REVISION SUBMISSION - 08 / 22 / 2022

PERMIT# ERES2207-0045 If we don't have one yet, check here.

Project Address: 86 Gwendolyn Way, Fuquay Varina NC 27526

REVISION SUBMISSION – POST PERMIT ISSUANCE

SHEET NAME:
ELECTRICAL

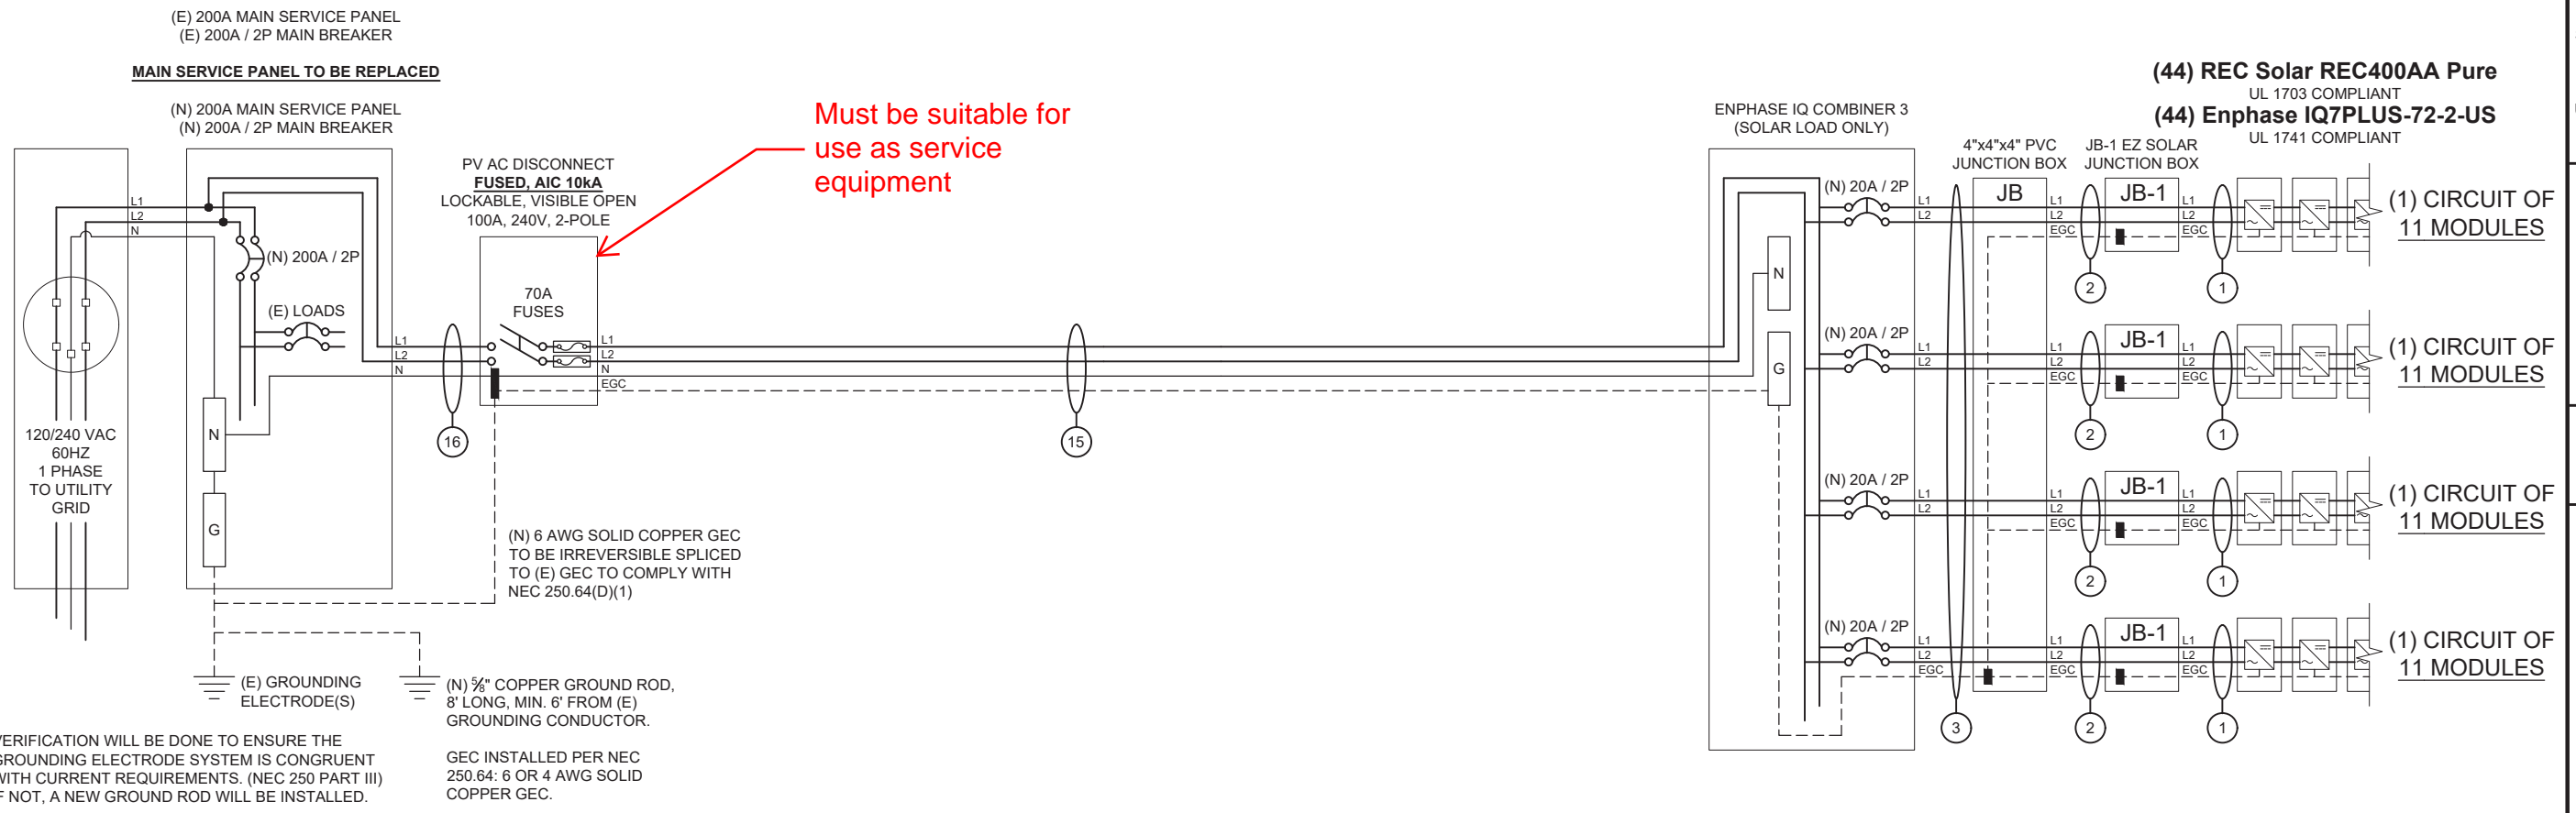
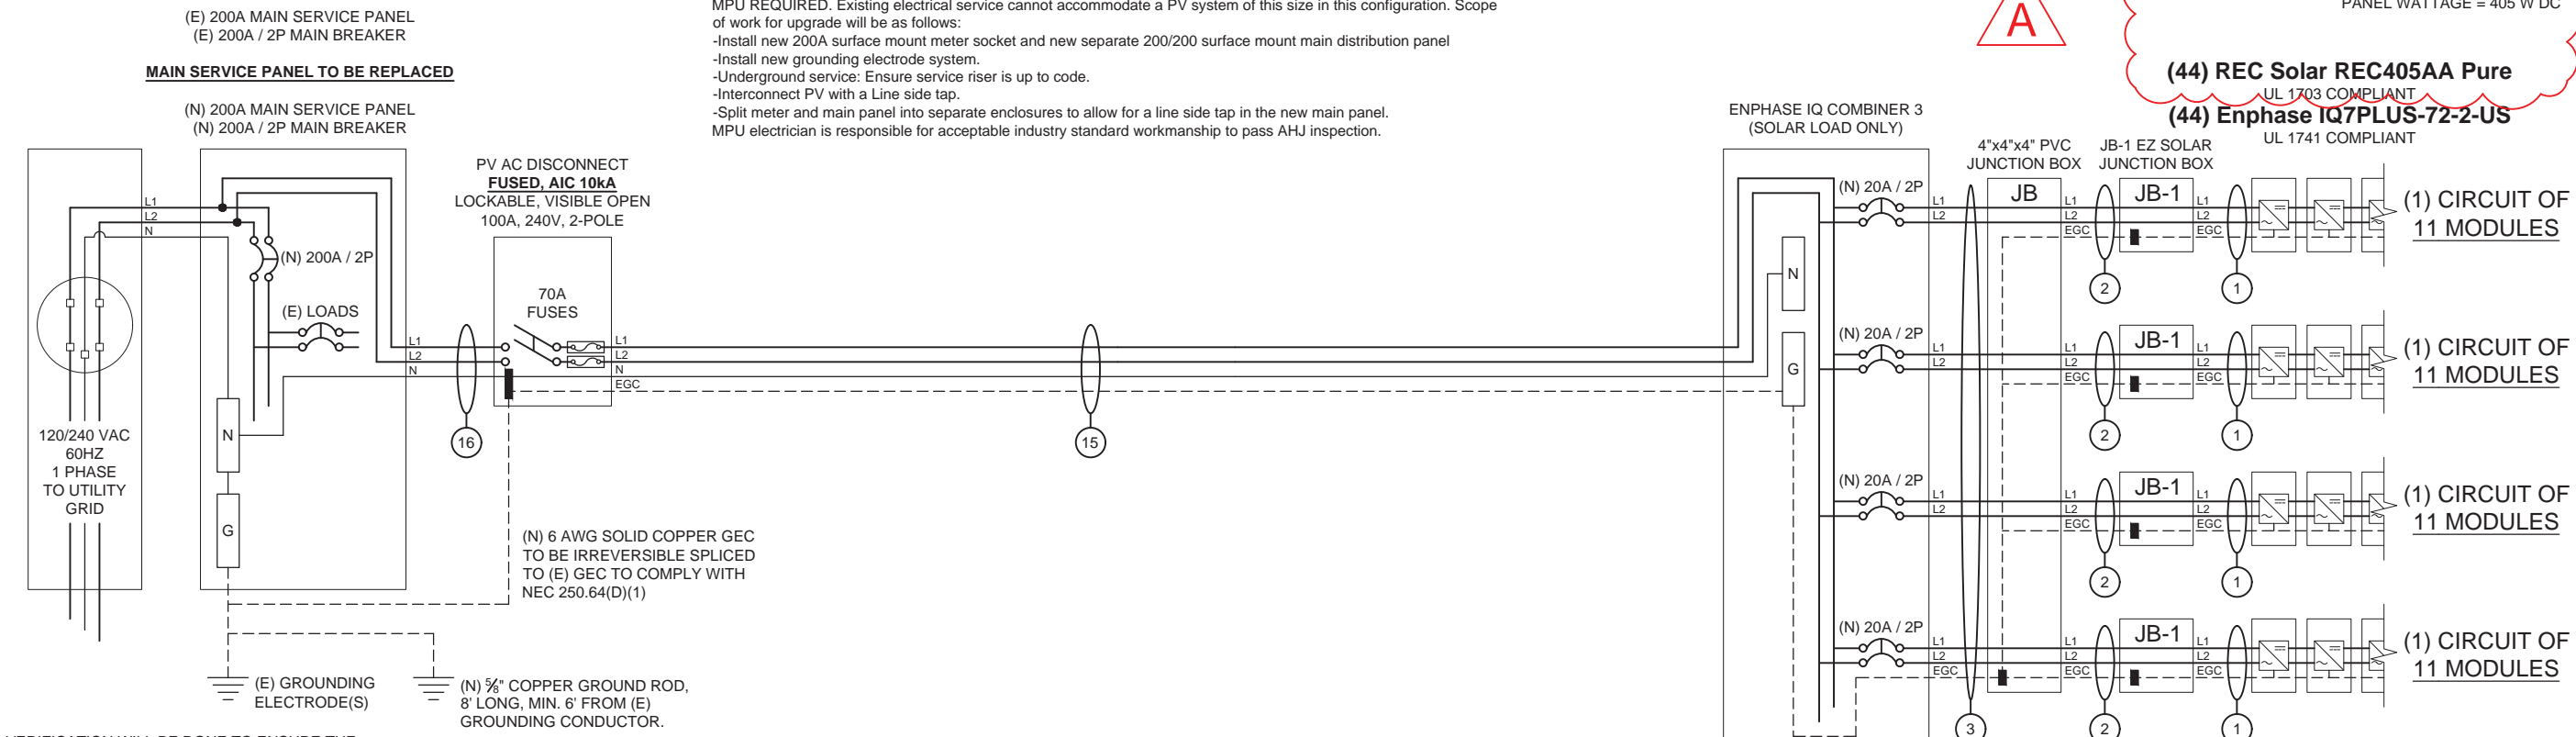
Details: Updated to show the module rating.
